A263-22 GJ|T/GT Amended
Planning Department
Arun District Council
The Arun Civic Centre
Maltravers Road,
Littlehampton,
West Sussex
BN17 5LF

Ref: Planning approval AW/119/22/HH dated 6th July 2022: Front Porch and kitchen extension at

25 Craigweil lane, Aldwick, Bogor Regis Arun PO21 4AN

I have pleasure in attaching 3 amended drawings, A263-02B, A263-22-03B & A263-22-04A.

TITLE:
25 CRAIGWEIL LANE
BOGNOR REGIS
WEST SUSSEX
PO21 4AN
SITE # LOCATION PLAN

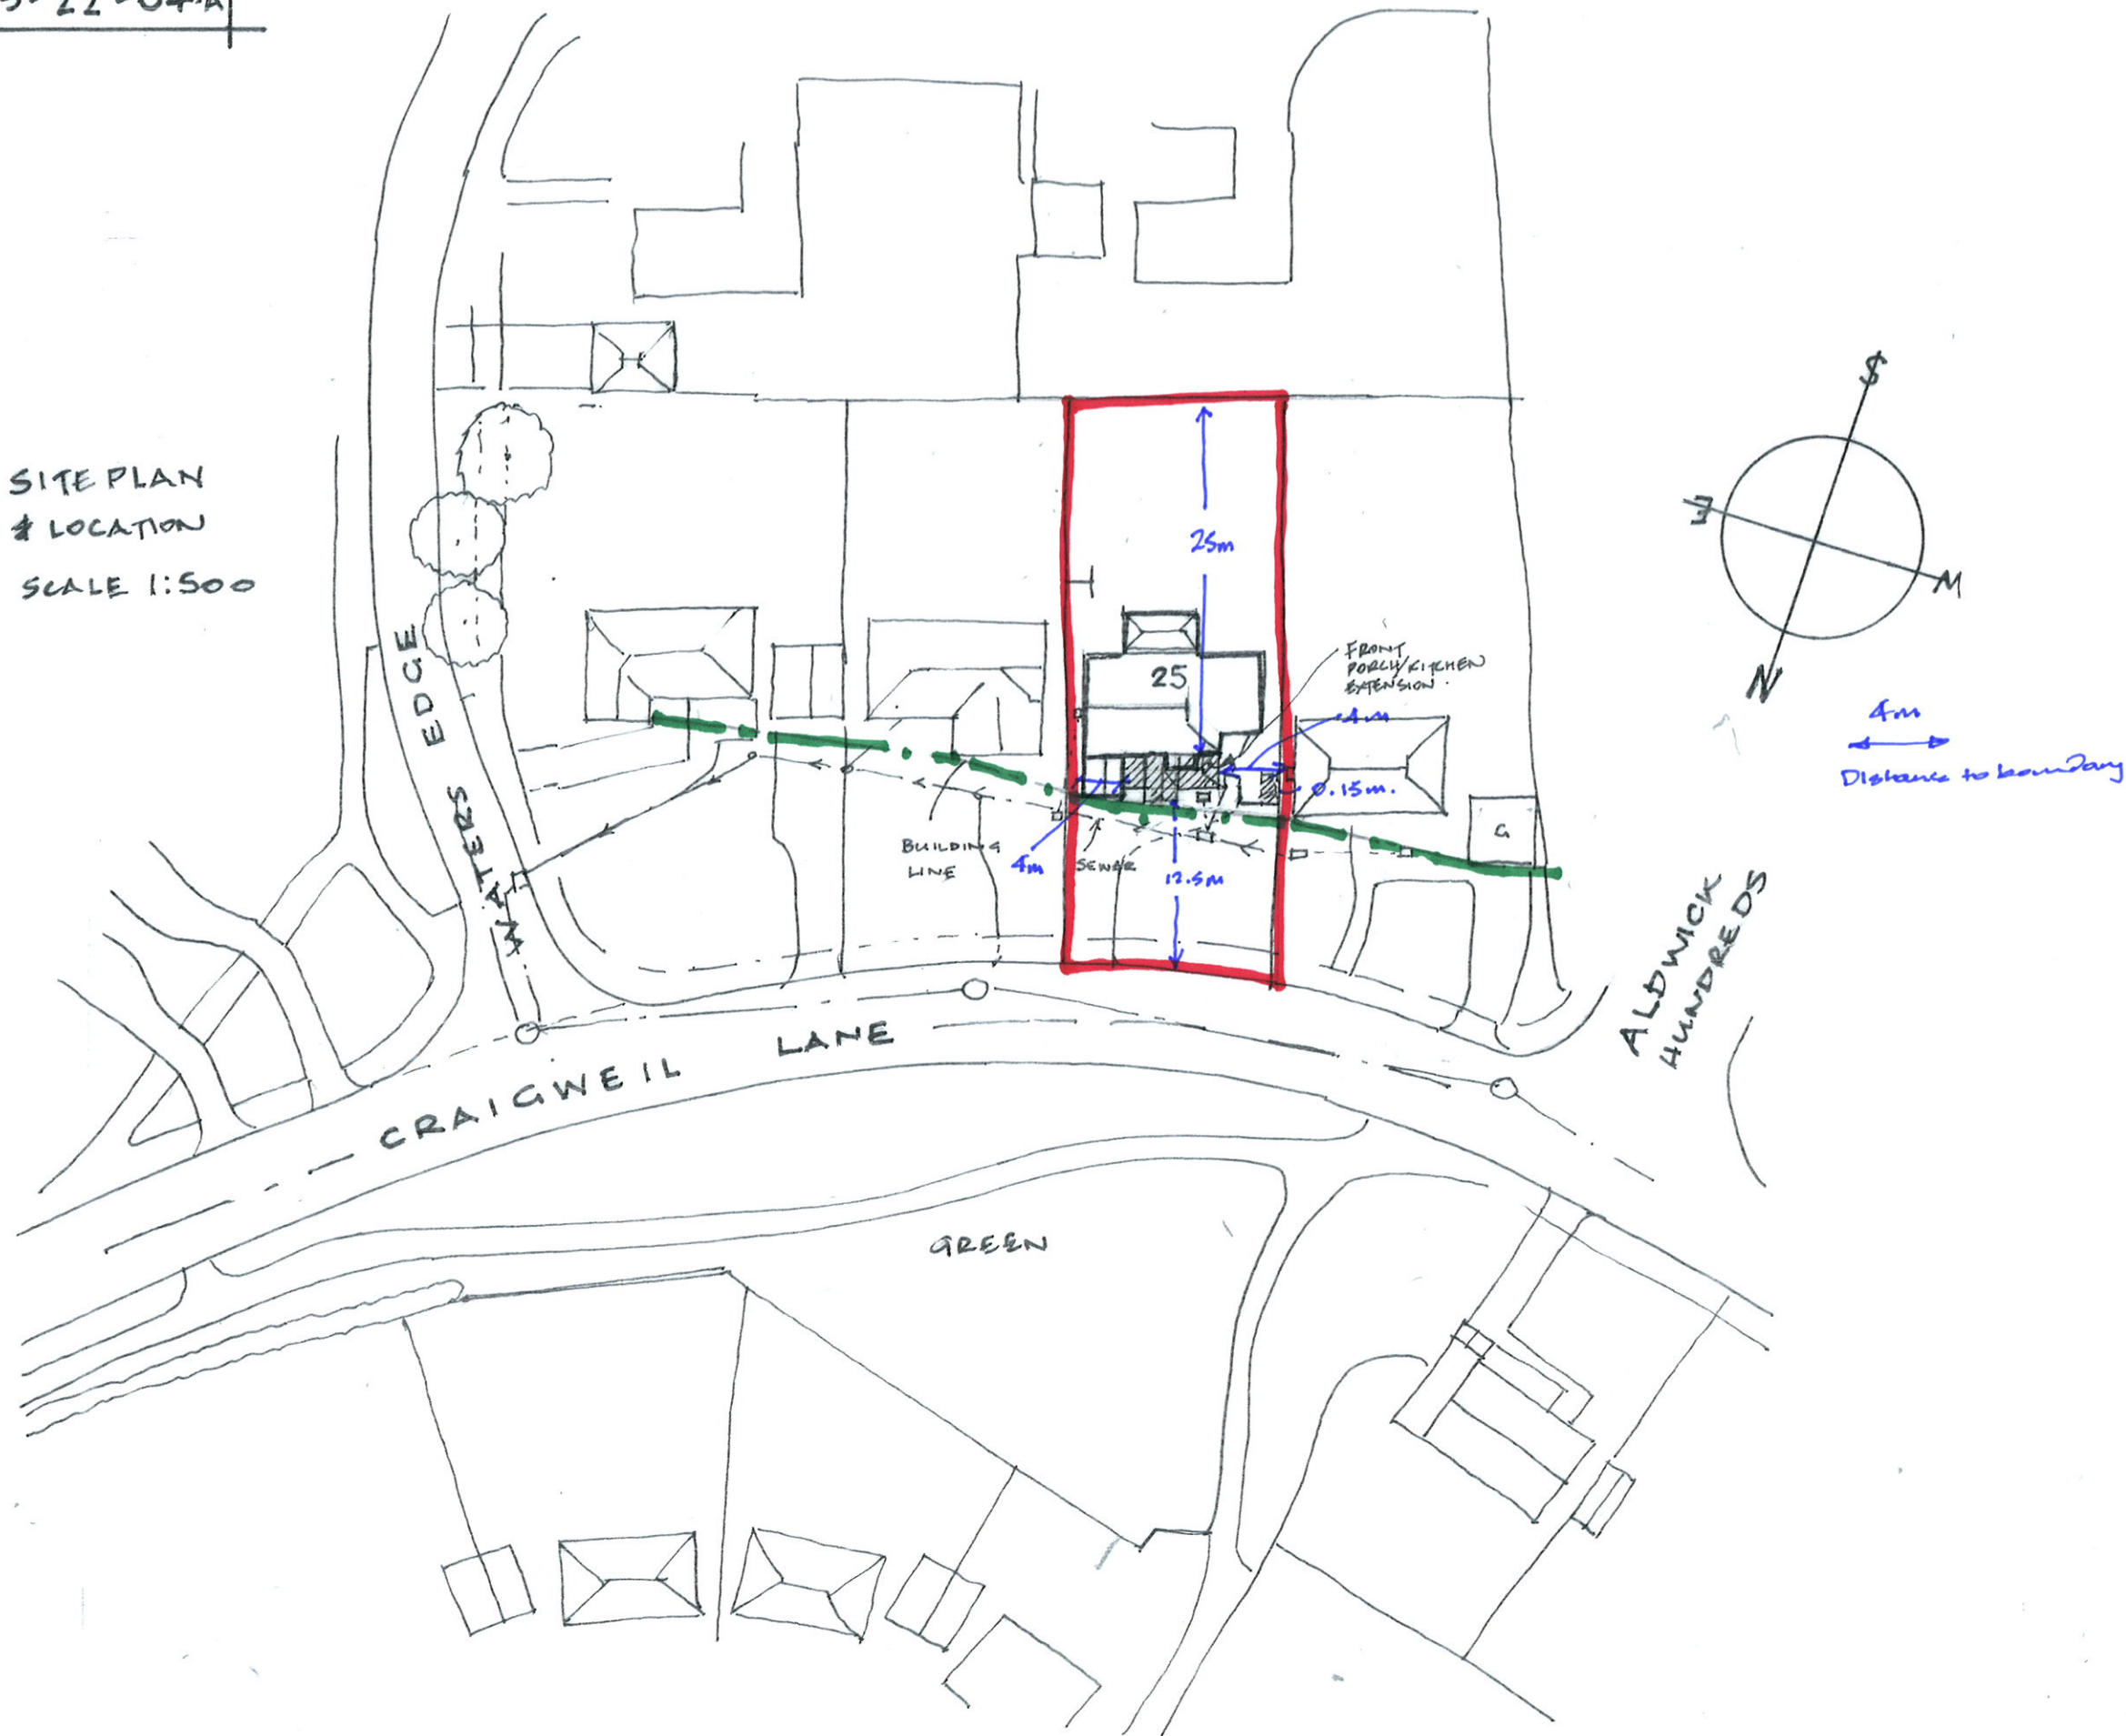
External Brick Shed behind the repositioned boundary wall.

They also asked to build a small brick shed/store behind the reformed brick boundary wall

Due to the height of the reformed wall the flat roof shed will not be seen at all from the front.

TITLE:
25 CRAIGWEIL LANE
BOGNOR REGIS
WEST SUSSEX
PO21 4AN
ELEVATIONS.

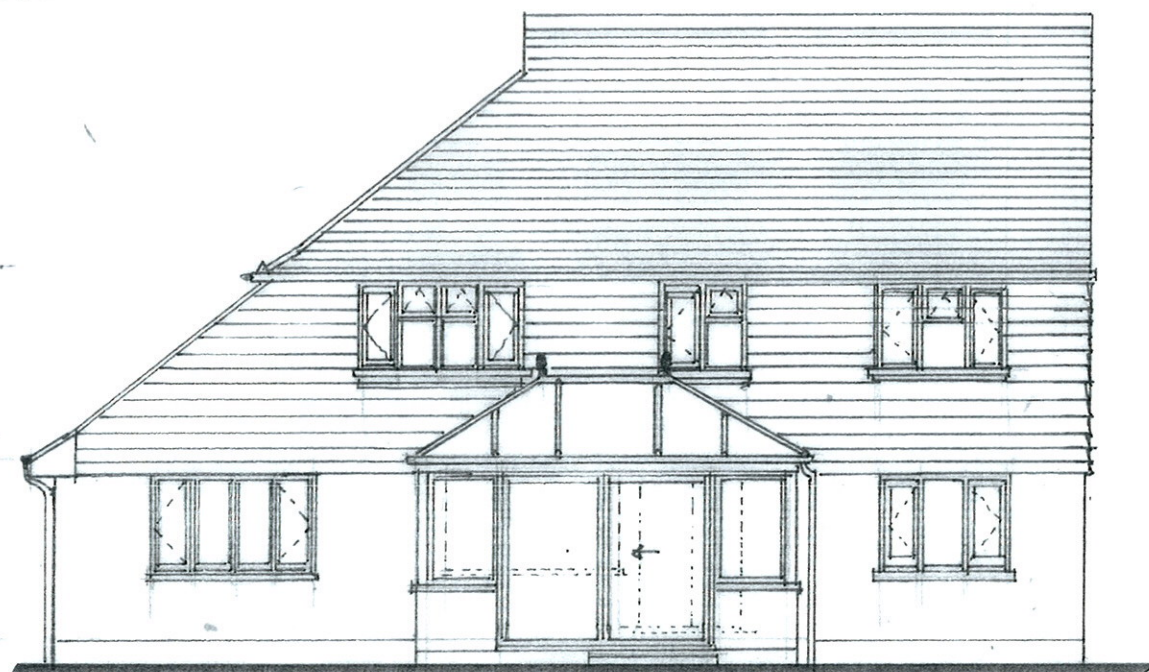
Building a small garage store in the gap between the new porch extension and the existing garage to the front.

To maintain the visual quality of the existing proposals as approved no windows in the elevation of the store will be added. The tiled sloping edge roof detail matches that over the kitchen, repeated over the store hiding another small skylight for natural light as with the kitchen extension. To maintain elevation relief I pushed the porch just one brick 210mm forward to create the vertical brick lines and maintain the centre feature of the porch all done under the same roof projection.

25 CRAIGWEIL LANE
BOGNOR REGIS
WEST SUSSEX
PO21 4AN
PROPOSED PLANS

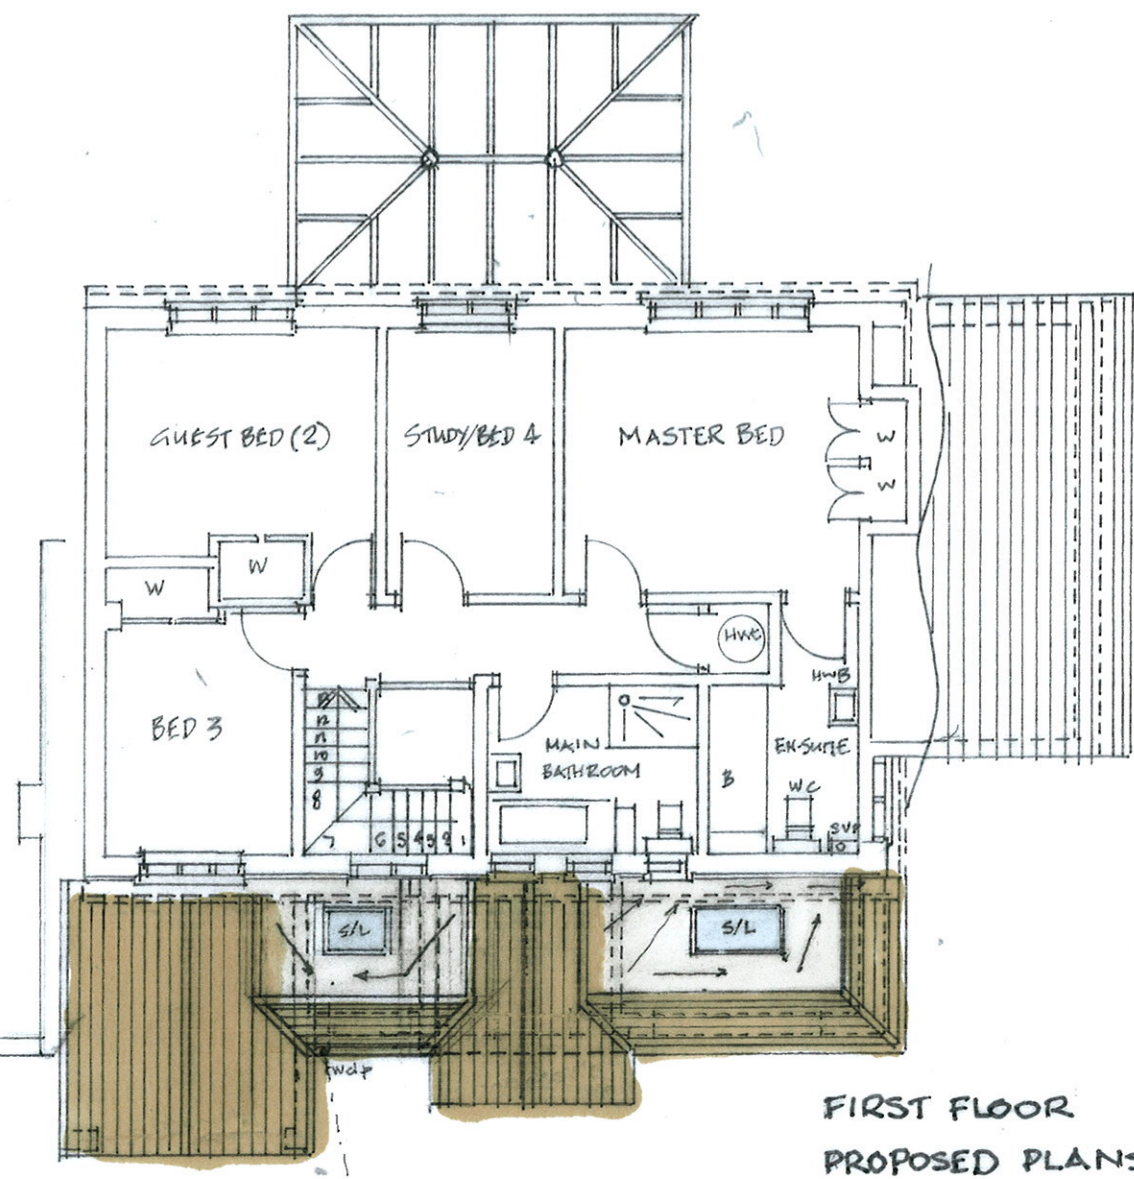
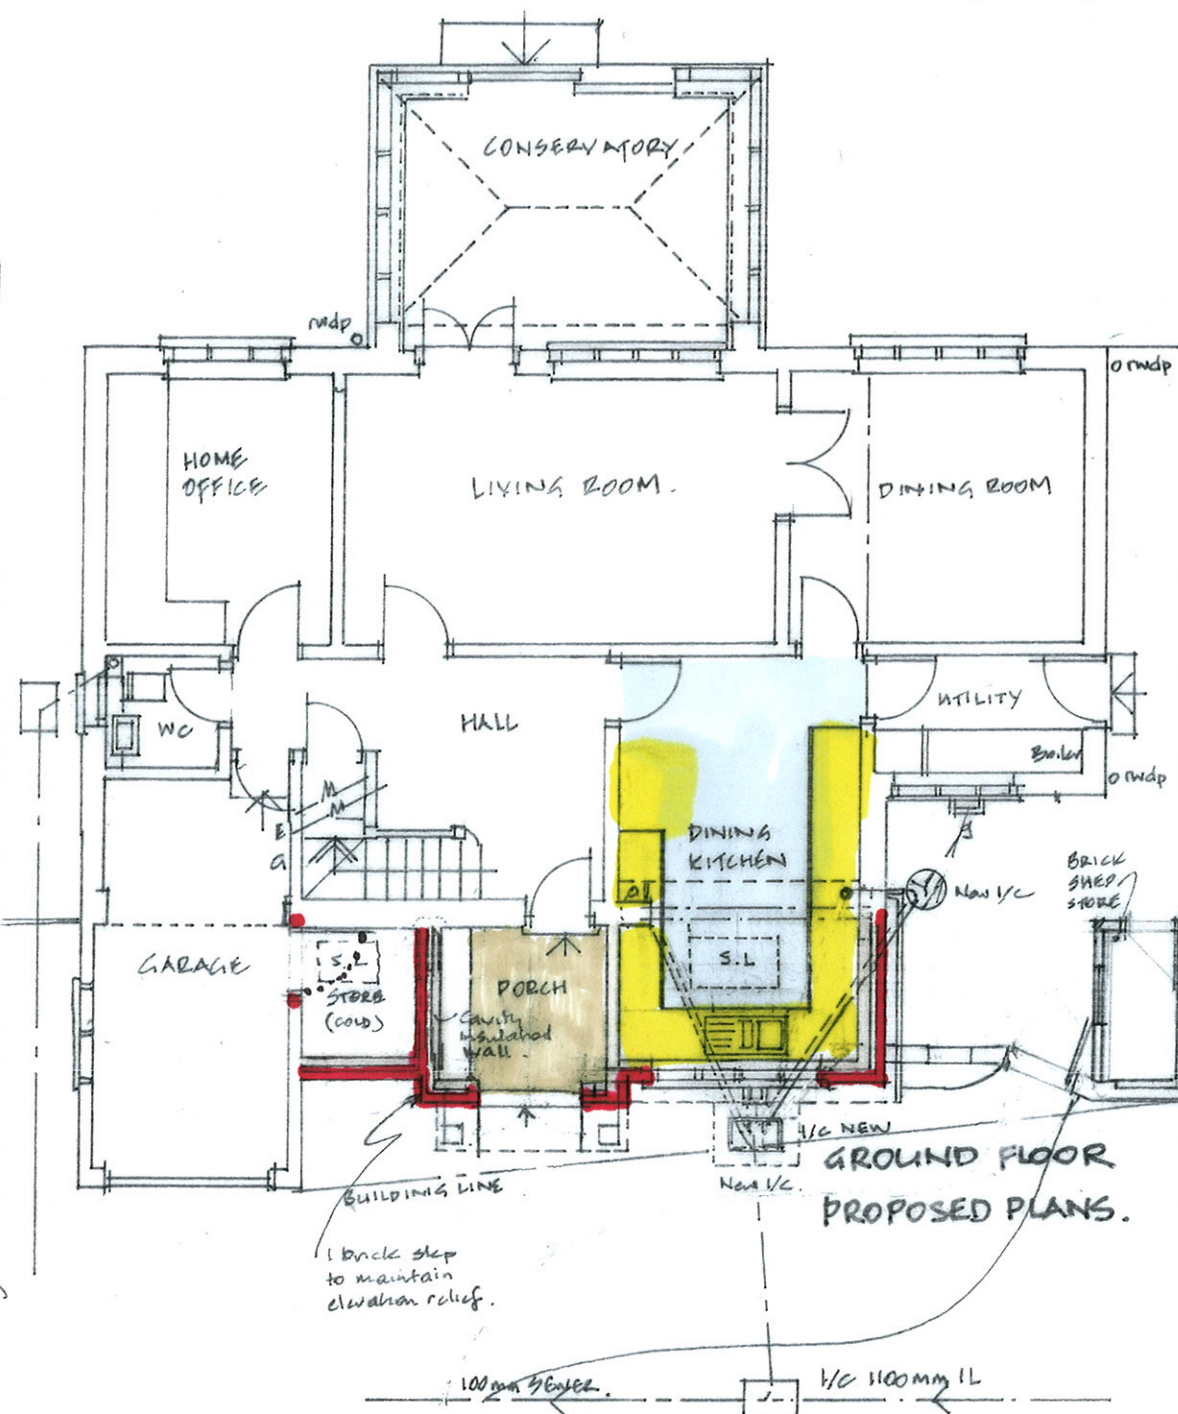
garage. This would however bring the garage forward of the existing building line. Though this may not present any major issues in planning, I had proposed an alternative to build a small store in the rather unhelpful gap between the new porch and the existing garage.
